Pre-application Advice from OCC

OXFORDSHIRE COUNTY COUNCIL'S RESPONSE TO CONSULTATION ON THE FOLLOWING DEVELOPMENT PROPOSAL

Location: Land at Promised Land Farm, Wendlebury Rd, Bicester OX25 2PA.

Application no: 18/CH0010/Preapp

Figure 5 – Proposed Vehicular Access to Business Park

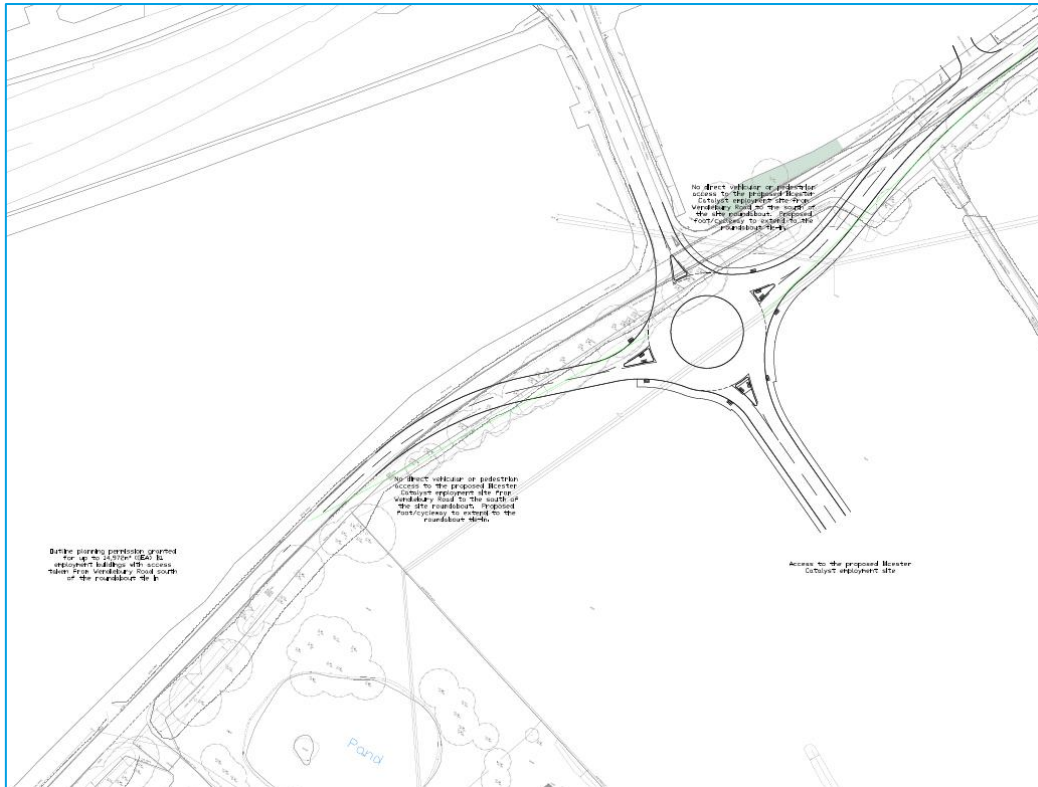
Vehicular and principal pedestrian/cycle access is proposed to come off Wendlebury Road with a formation of a new 4-arm roundabout. The new roundabout would serve the Wendlebury Road (North and South arms), site access and the Vendee Drive roundabout link will form the east and west arms respectively.

Para 8.4 suggests that the proposed roundabout that would form access onto Wendlebury Road has already been capacity tested which has confirmed that traffic can be accommodated at the roundabout. Modelling results are hence required for this roundabout.

Wendlebury Road is part of the local rural road network and so access along it for traffic generated should be carefully investigated. The model appears to be utilising the A41 junction with Wendlebury Road for access to the site from traffic from the north via the LILO junction, past Bicester Avenue. Wendlebury Road from the A41 does not appear suitable to accommodate likely trips generated by this scale of development due to its width and apparent construction. For this to be acceptable, an upgrade of Wendlebury Road will be required between the A41/Wendlebury junction and the proposed site access. The upgrade shall be required to make it suitable for the increased traffic and also provision for pedestrian and cycle access.

Figure 6 – Proposed Pedestrian Route

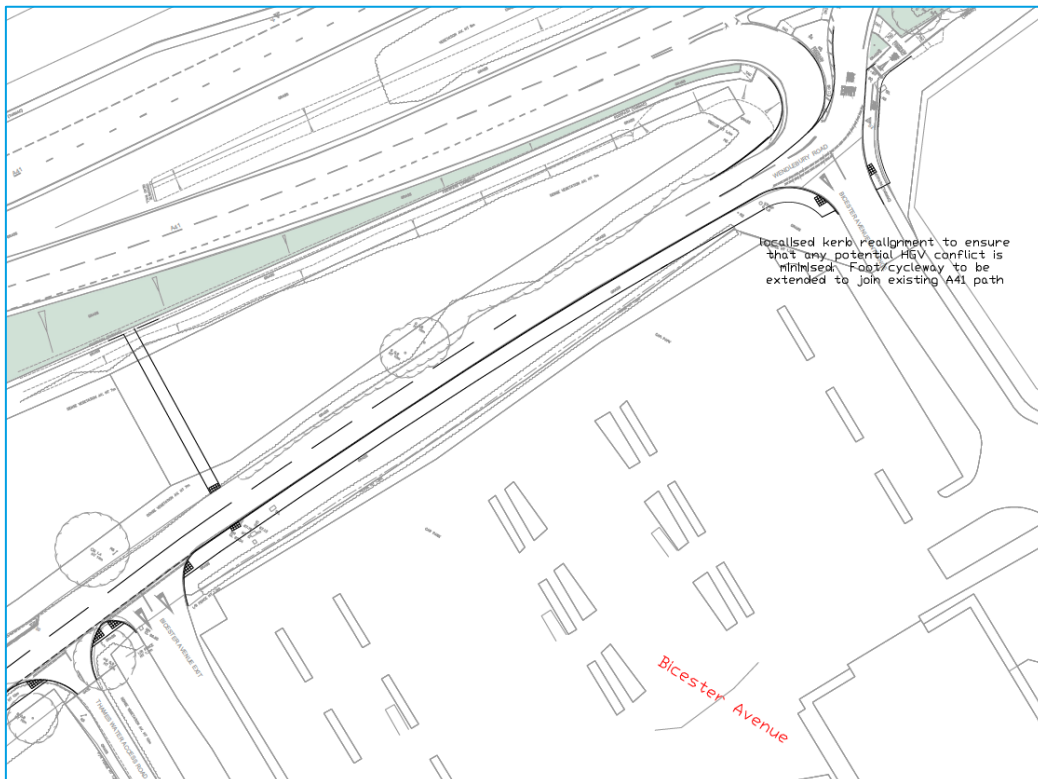
Although provision has been provided for those walking immediately out and into the site, the application needs to provide continuous pedestrian facilities/routes from the existing highway: directly towards the bus stops on the A41, and northwards along Wendlebury Road to its junction with the A41.

Wendlebury Road is a Sustrans cycle route (NCN51) and consideration will need to be given to how the development proposals would tie into the existing cycle and pedestrian infrastructure without compromising safety and operation of the NCN51, taking into account the increased volume of traffic. I suggest that the application considers a cycle infrastructure provision along the site frontage to mitigate for the increased traffic. A cycle and pedestrian link should also be provided directly into the proposed John Lloyd centre from Wendlebury Road, to minimise walking and cycling distance for users and staff, thereby encouraging sustainable travel.

Figure 7: Preliminary Flood Compensation Scheme 1 (Drawing No. S1358-Ext-35A)

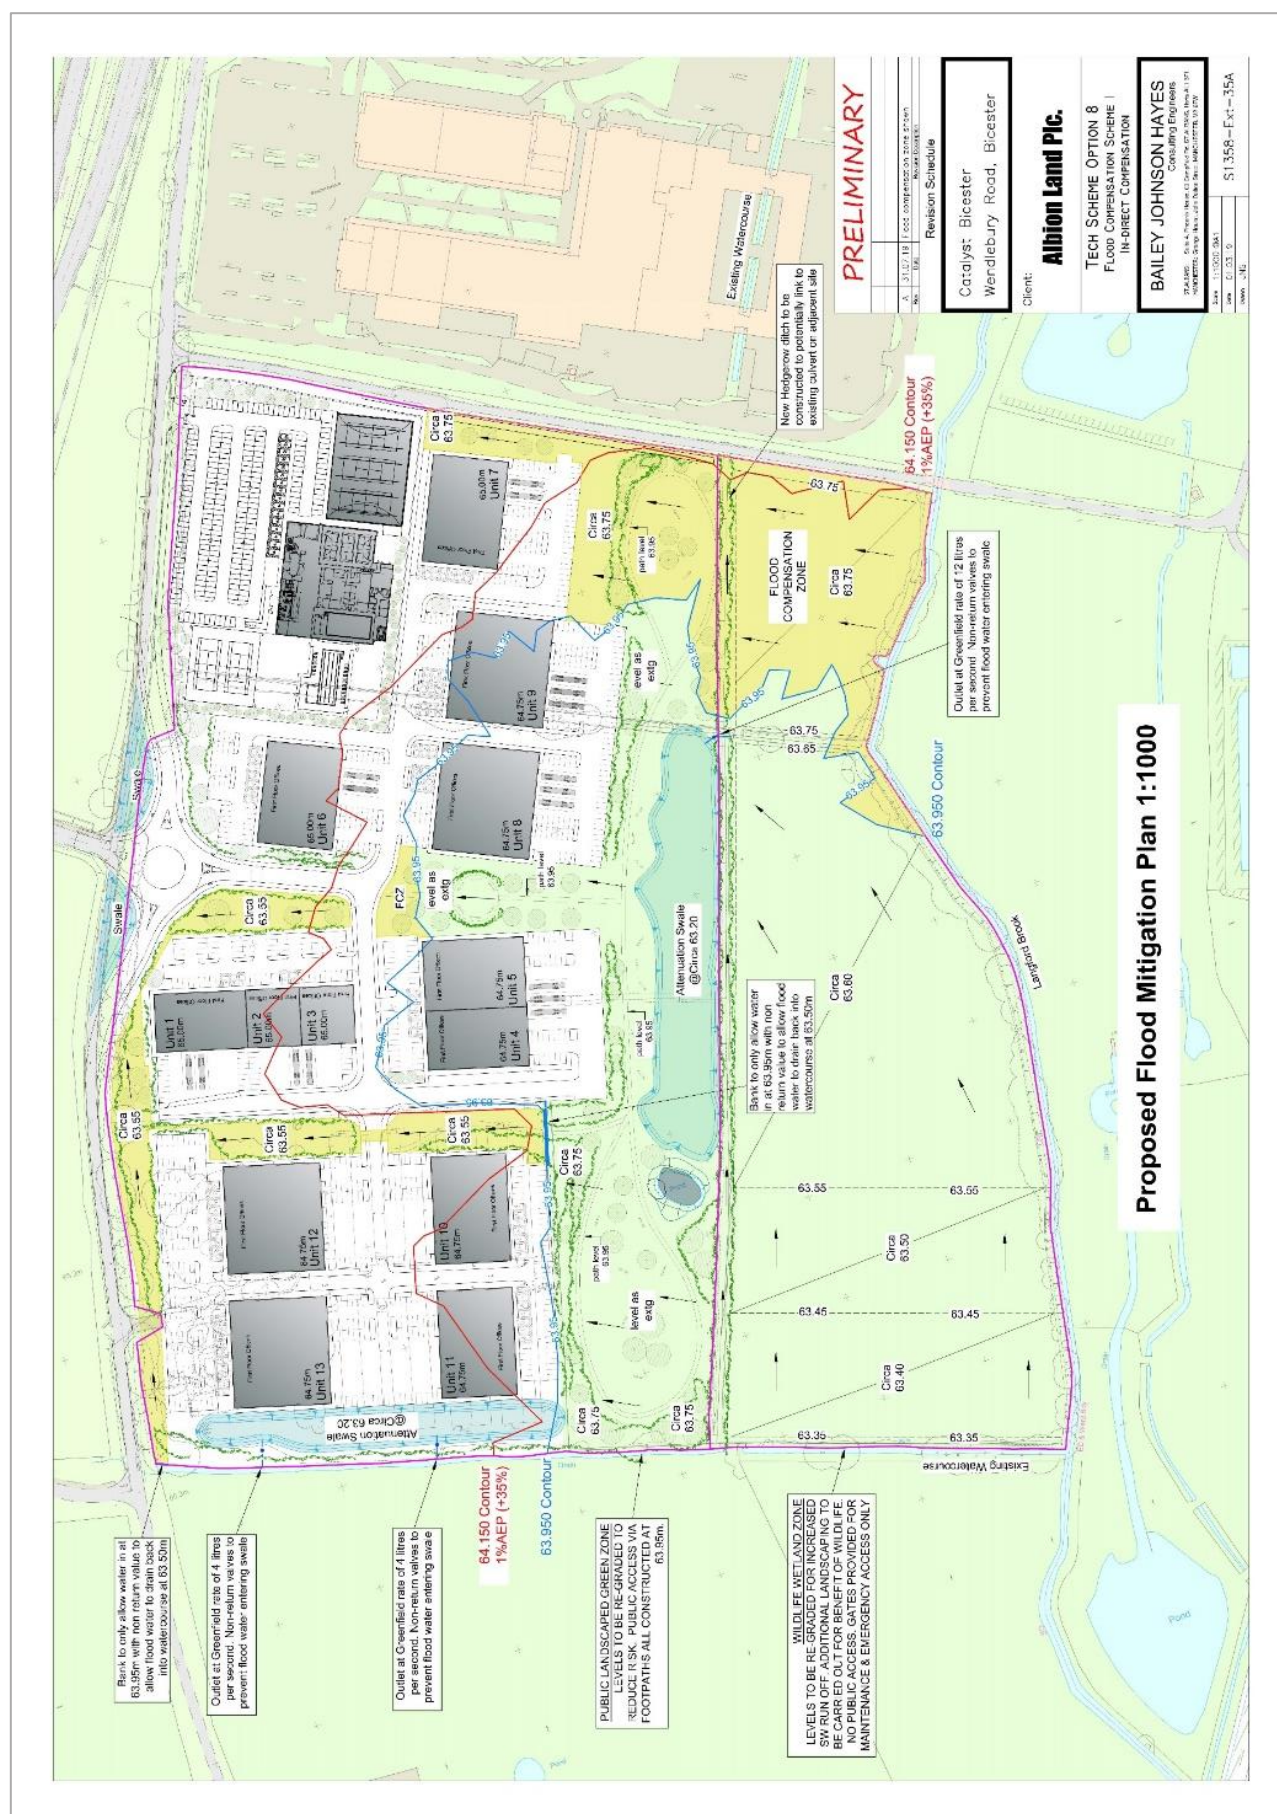
The majority of the site is shown to be in flood zone 3 and is also shown to be at risk of surface water flooding. A scheme to provide flood compensation is proposed which will need approval from the Environment Agency.

However the LLFA have significant concerns to the proposals as the compensation is being provided by significantly lowering the existing ground levels which are likely to be below existing groundwater levels.

However, we cannot support the application until an adequate flood compensation scheme has been provided and approved by the Environment Agency, which demonstrates the development and proposed attenuation will be outside of the proposed flood plain and will not be compromised by the fluvial flood levels.

Proposed Drainage Layout 1:500

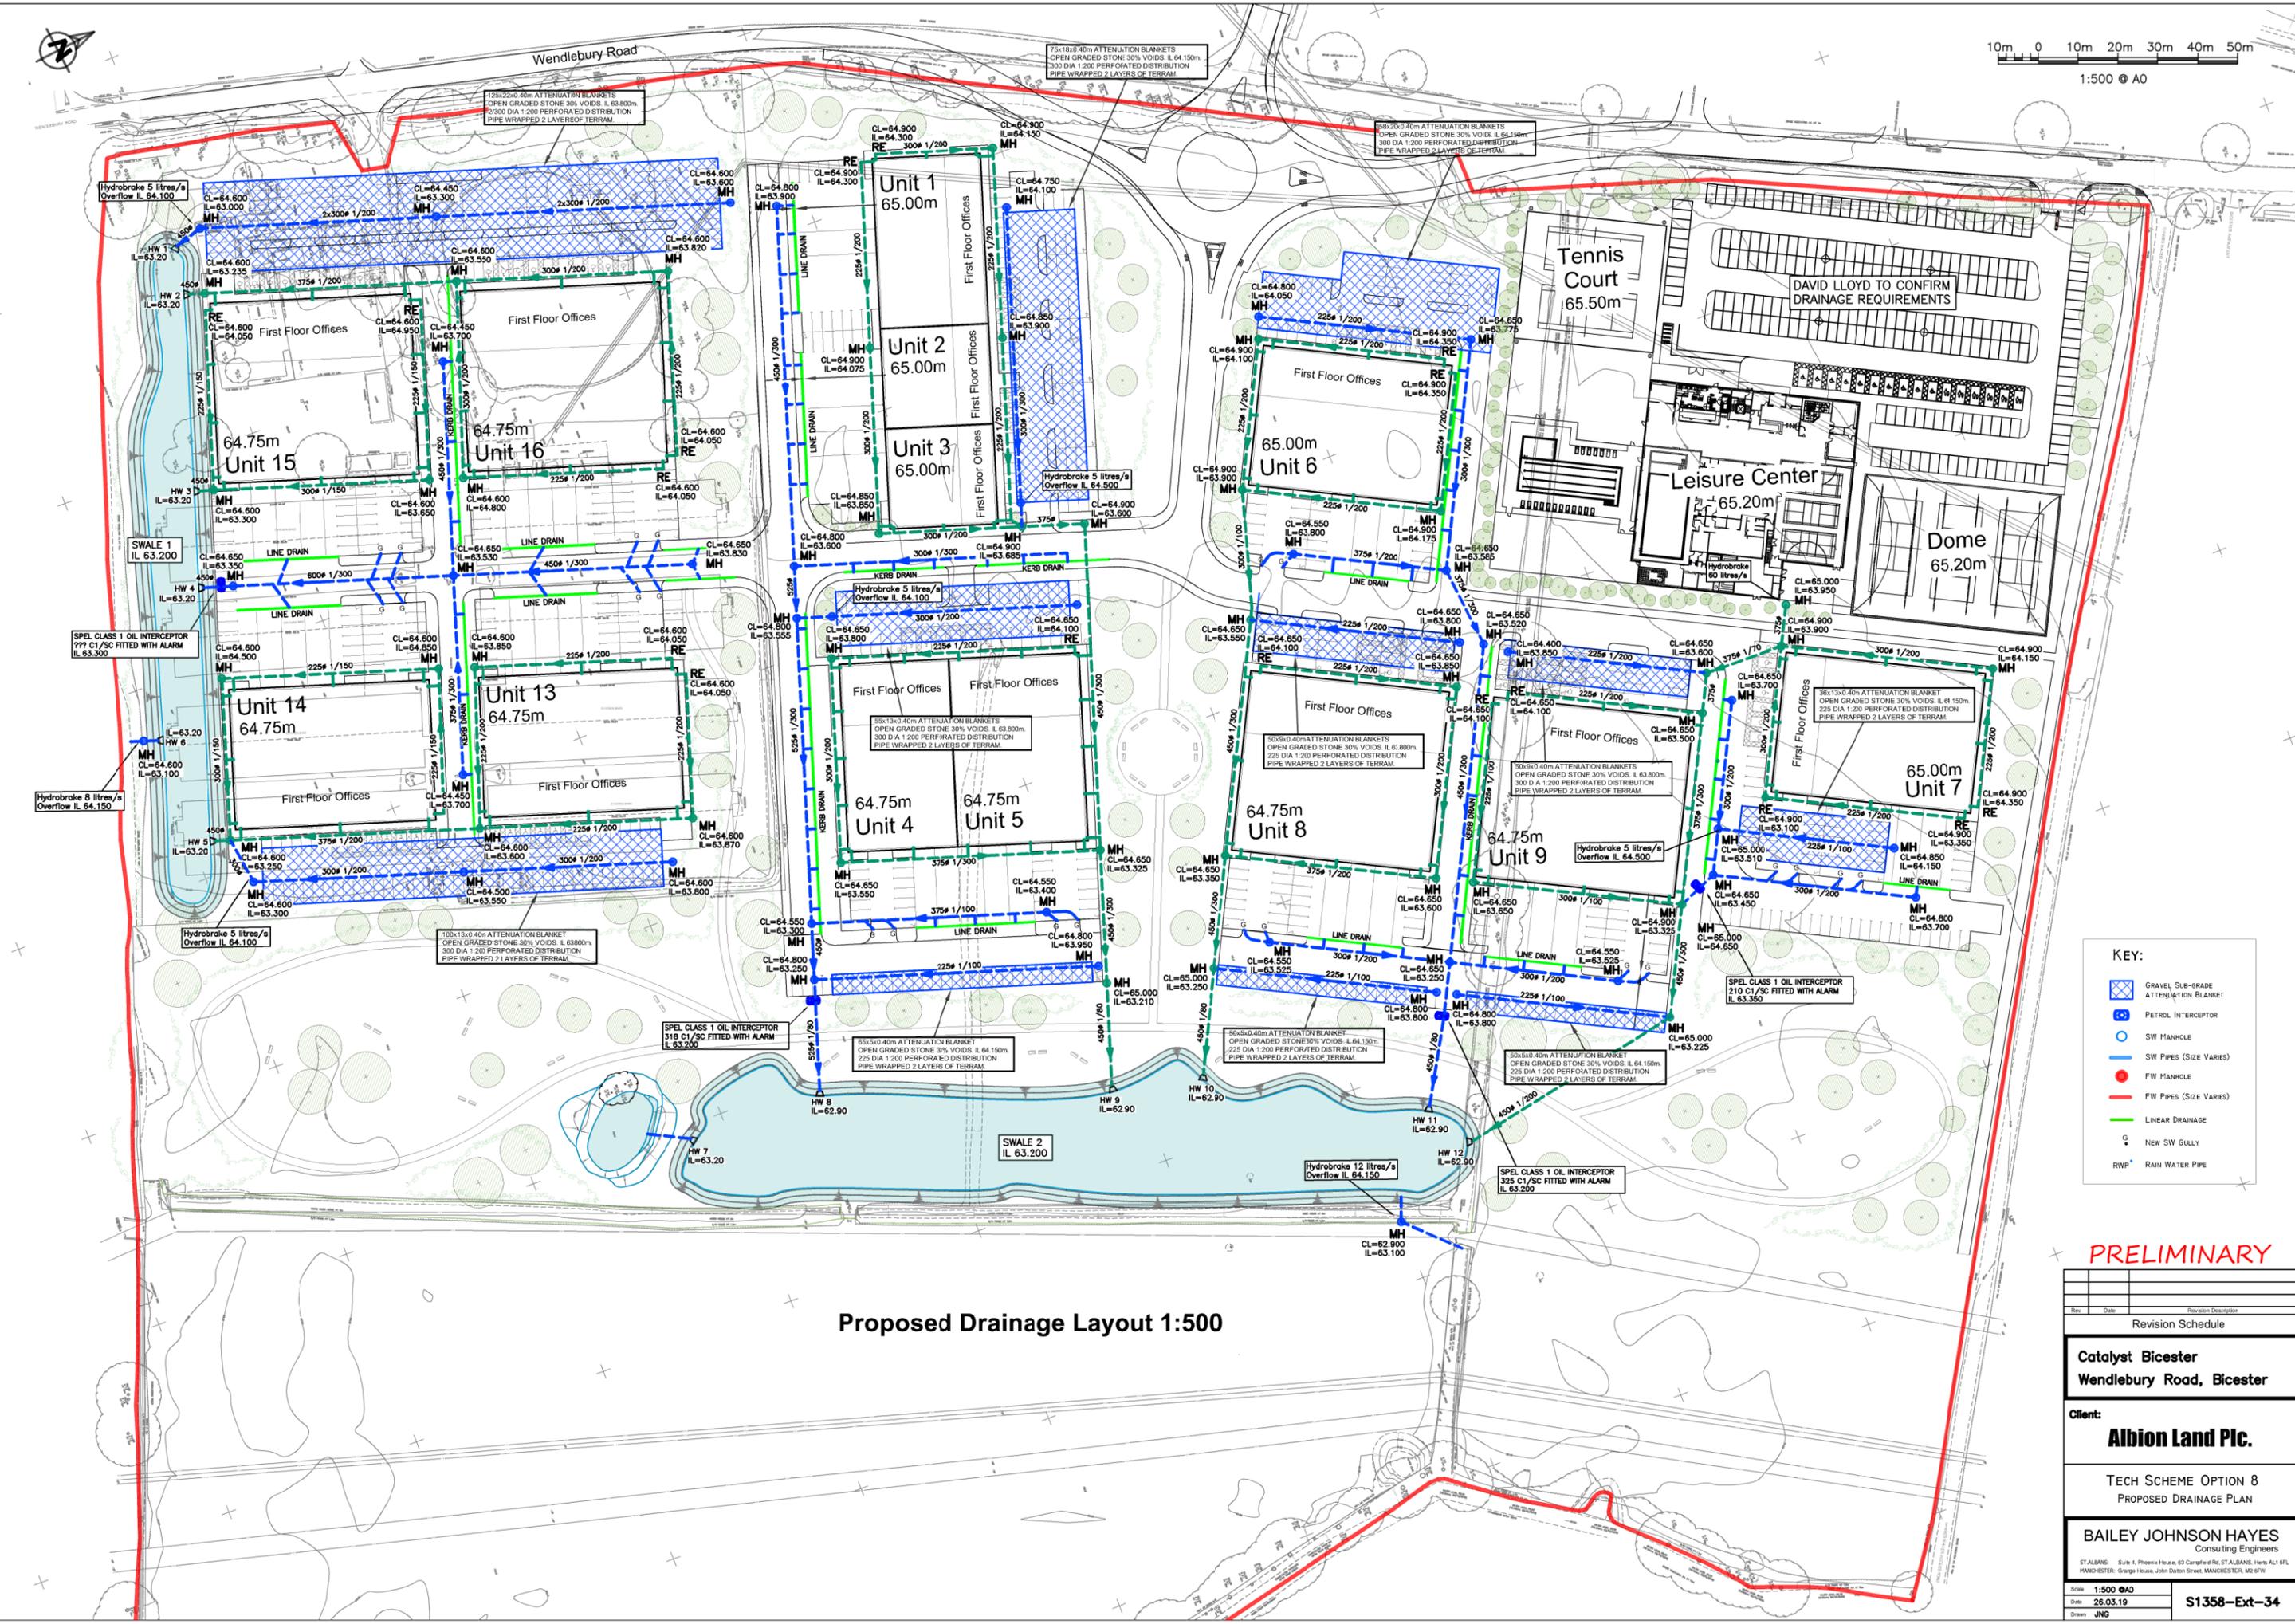
The current proposals show existing ditches and an existing well established pond to be removed. The LLFA cannot support the removal of these features. The ditch that flows west to east through the site from the Wendlebury Road is likely to provide a drainage function for the highway drainage and potentially other offsite land. The existing drainage regime needs to be fully understood.

We will expect source control measures to be incorporated within the development wherever possible. The current proposals are proposing limited source control features and the attenuation is mainly being provided by a deep swale adjacent to the proposed flood plain. The proposed level is significantly below exiting flood levels and therefore will not be acceptable.
